Issue Specific Hearing 10 (ISH10) on Biodiversity and Ecology

Theberton and Eastbridge Parish Council, B1122 Group and Stop Sizewell C

Oral Contribution by Cllr. Paul Collins

REVISION:
03

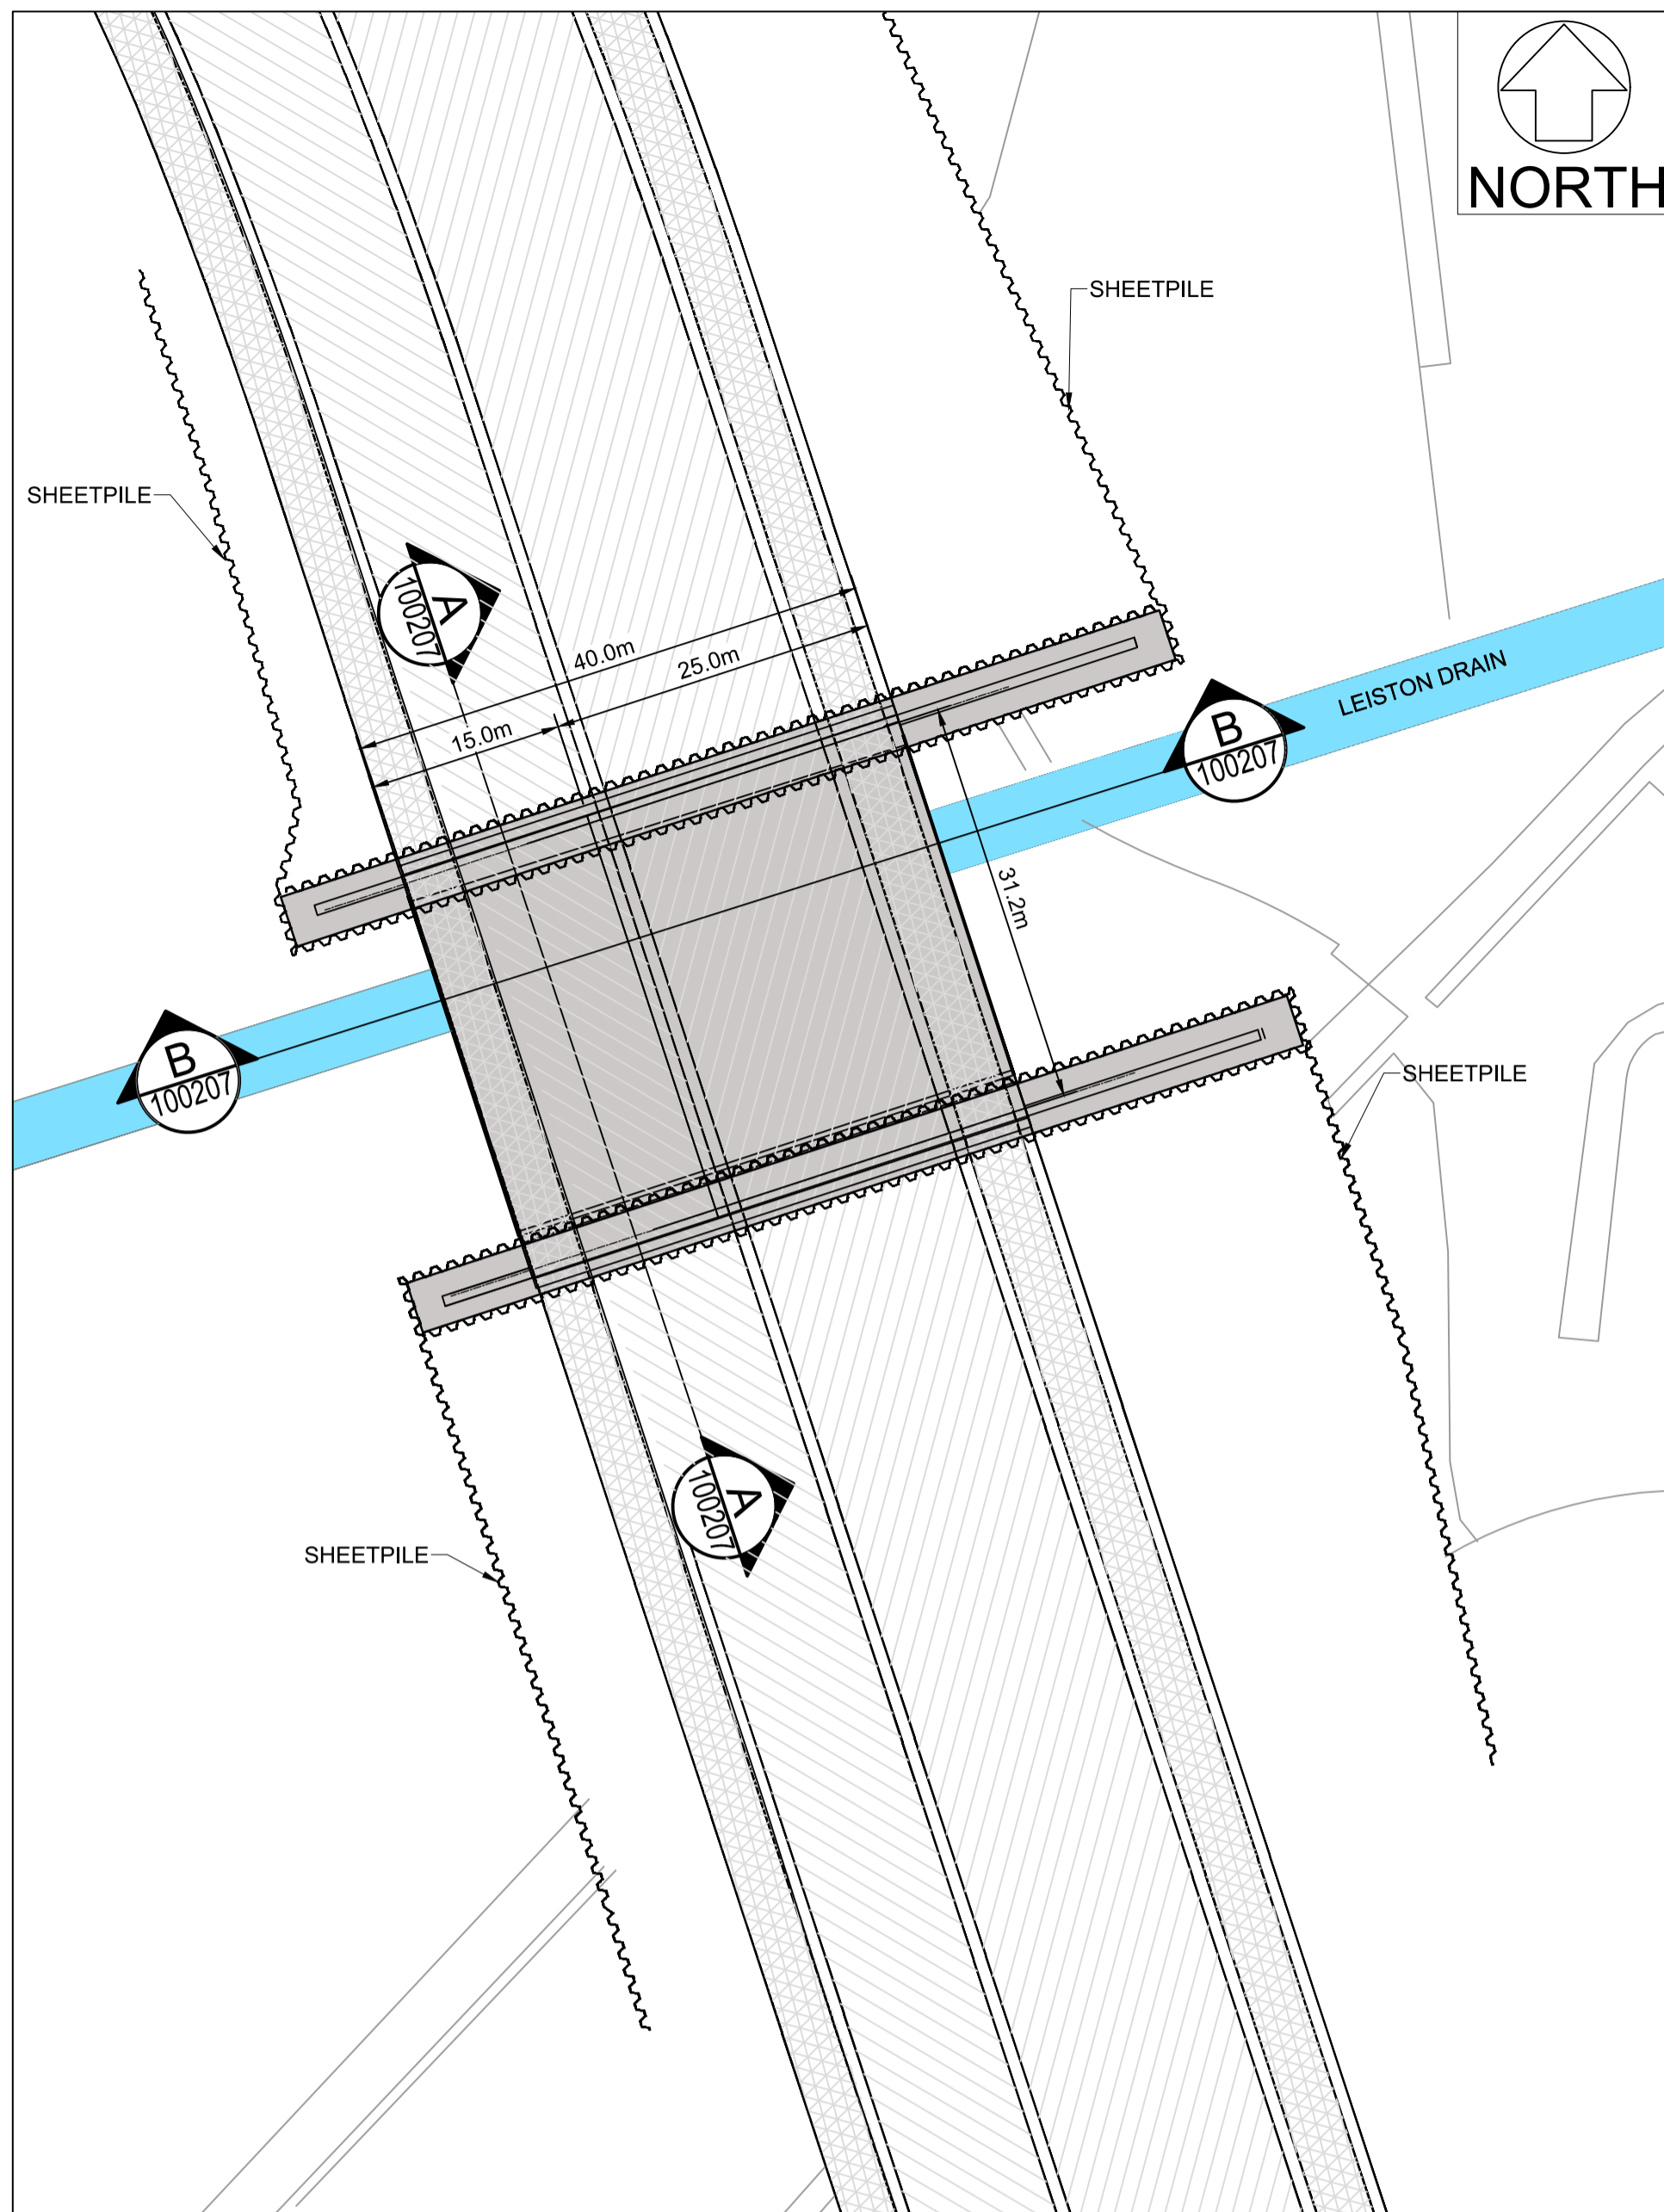
- o ***At all stages the SSSI Crossing structure is surrounded by sheet pile which is inappropriate considering the location within the SSSI and where eventually the restored Sandlings Path long distance route will be.***

The final 1:1 slope to the west of the structure will be completely incongruous in this location and there are concerns that it will not sustain good vegetation cover in the long term.

The concrete wings of the crossing initially supporting both main access and haul road/conveyor access cannot be disguised and are inappropriate in this location within the AONB and at the junction of the two SSSIs and Minsmere's other designations. Once the haul road crossing structure is removed, the concrete wings will become even more obvious in the landscape.

These comments simply go to reinforce the position of Stop Sizewell C and others that a more appropriate design is the 3 span bridge originally proposed at consultation 1.
